McKenzie Group Consulting (NSW) Pty Ltd
ACN: 093 211 995
Level 6, 189 Kent St, Sydney NSW 2000
Tel: 02 8298 6800 Fax: 02 8298 6899
email@mckenzie-group.com.au

RE: Presbyterian Aged Care Development – DoP request for additional information
BCA Commentary on Infill of Internal Void

DRAWING TITLE:  
**LEVEL 06 PLAN - STEPHEN STREET BUILDING**

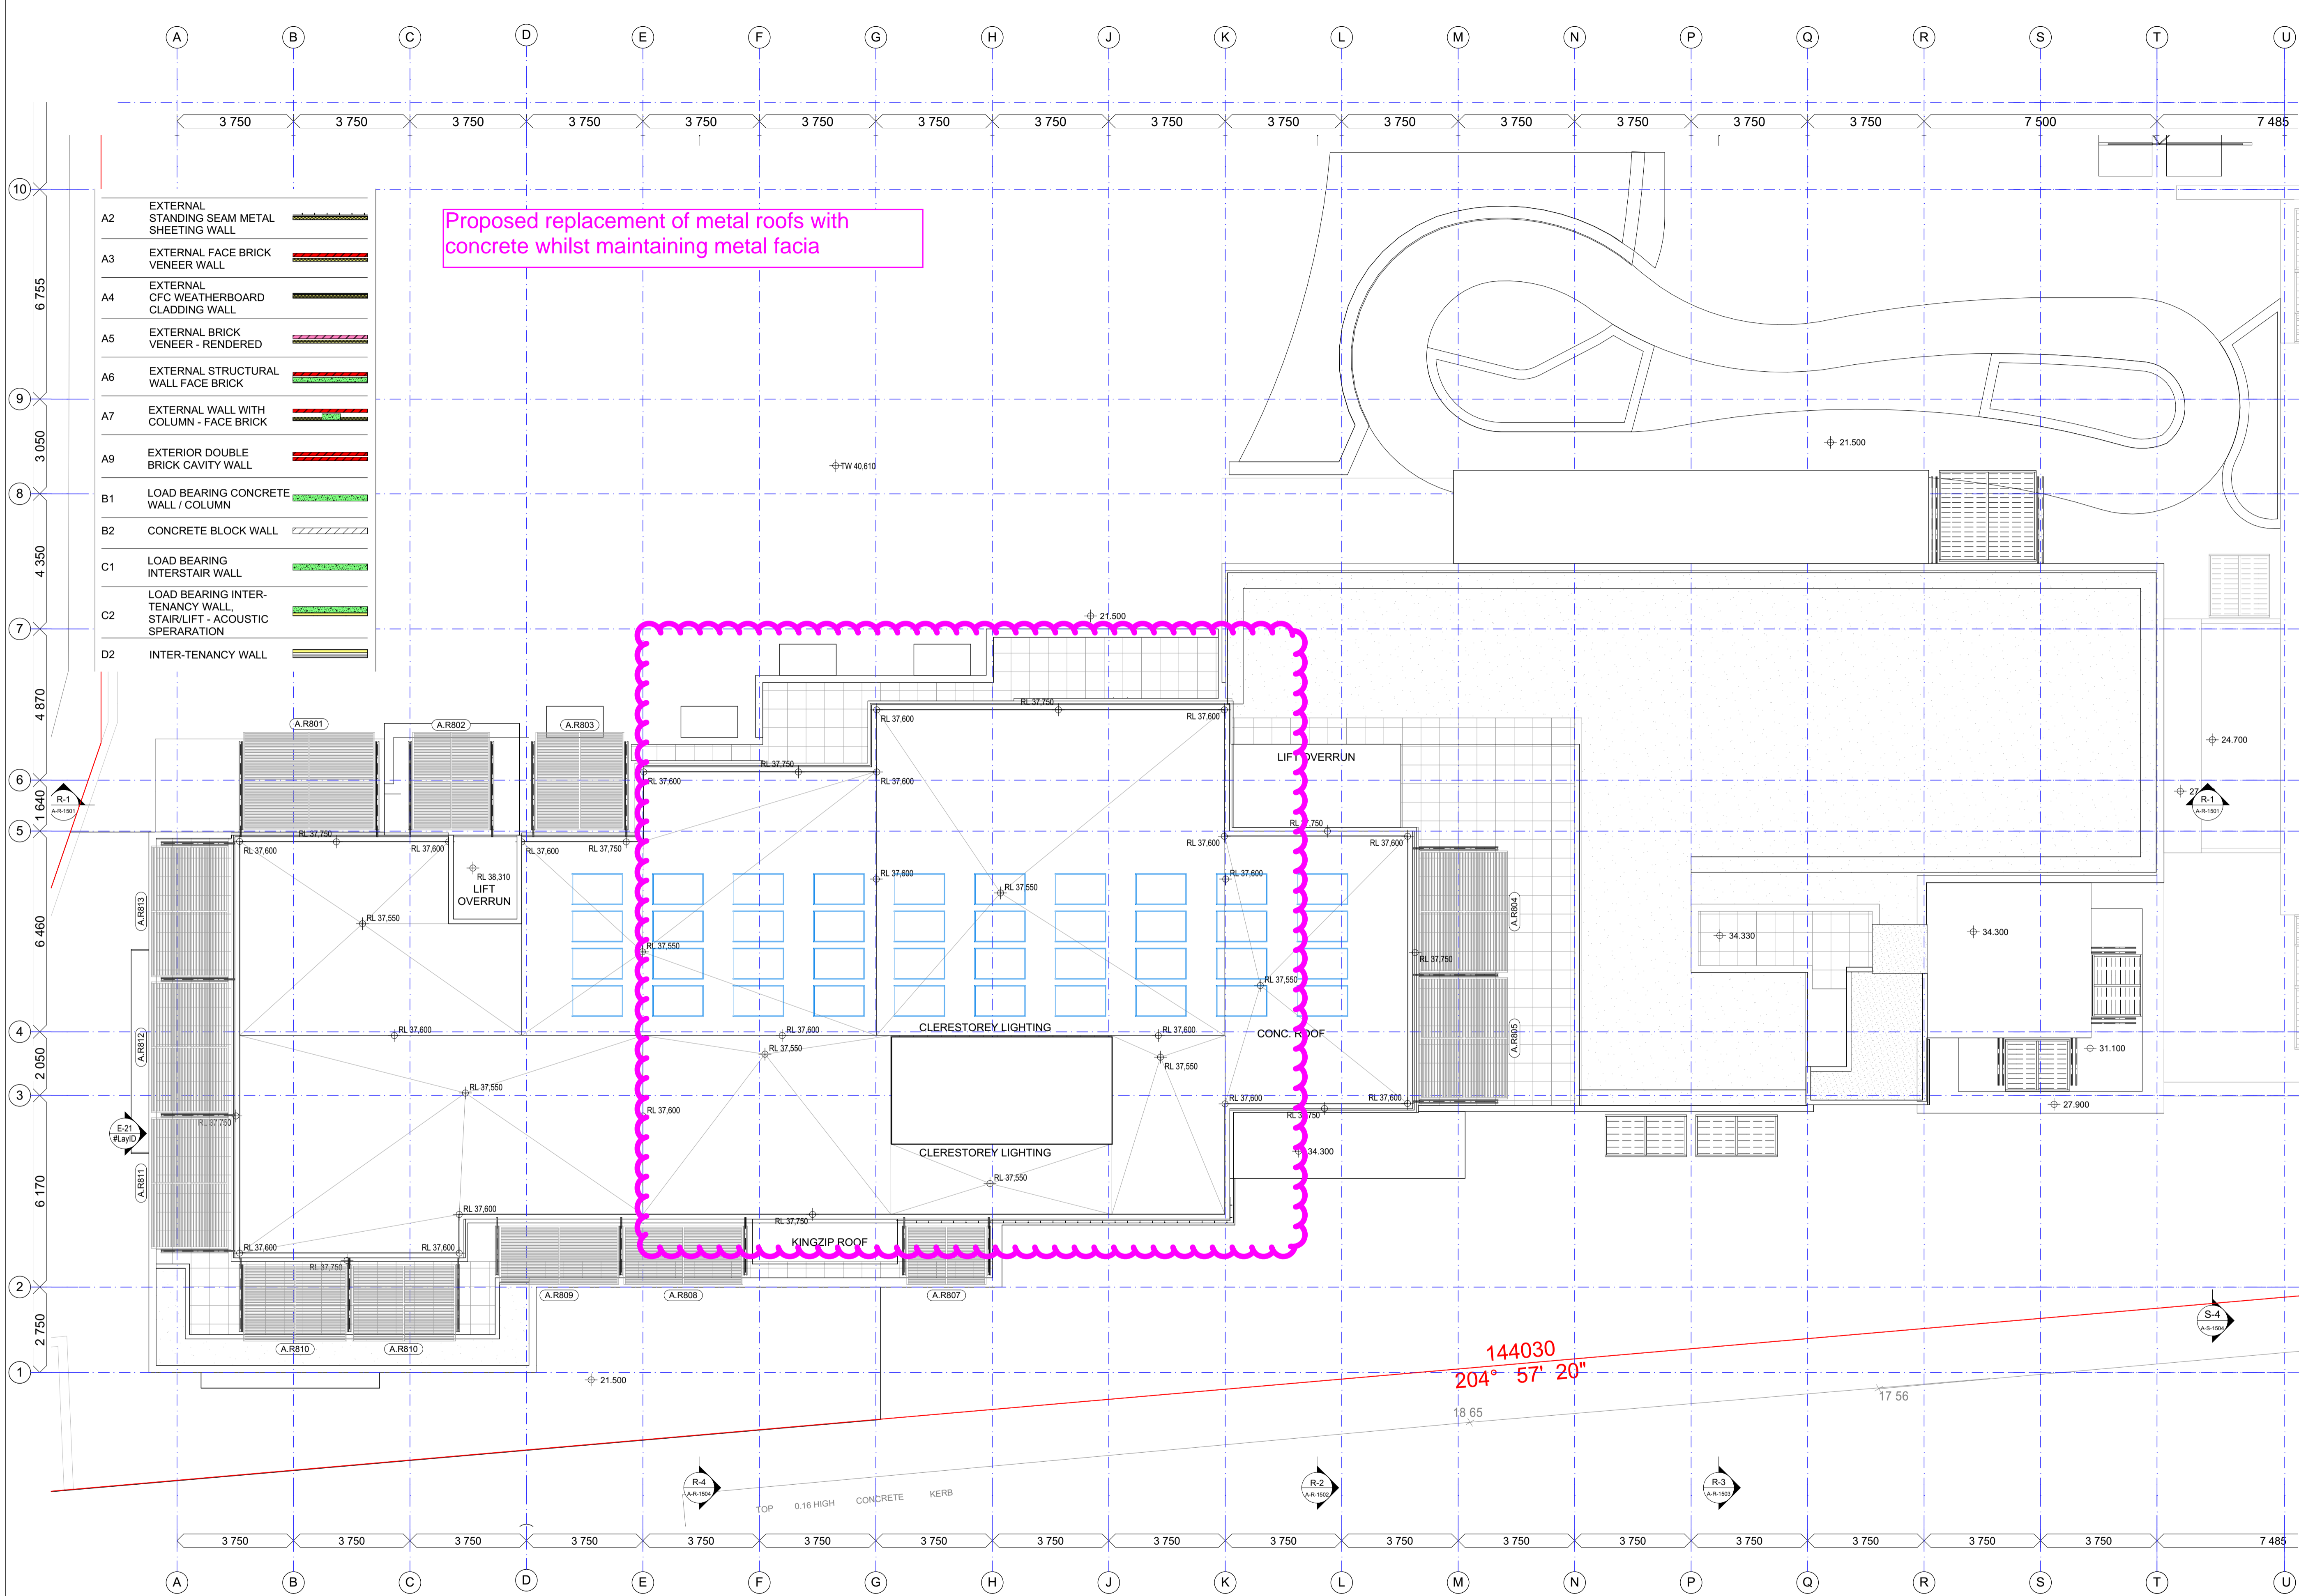
Further to our review of the latest correspondence received from the Department of Planning, we note that the Void located between Grid U-V, Stephen St Building will be required to be removed.

We confirm that the identified Void does not achieve compliance with the Fire Compartmentation Strategy nominated within the Fire Engineered Solution for the development, nor the requirements of Clause C2.9 of the BCA.
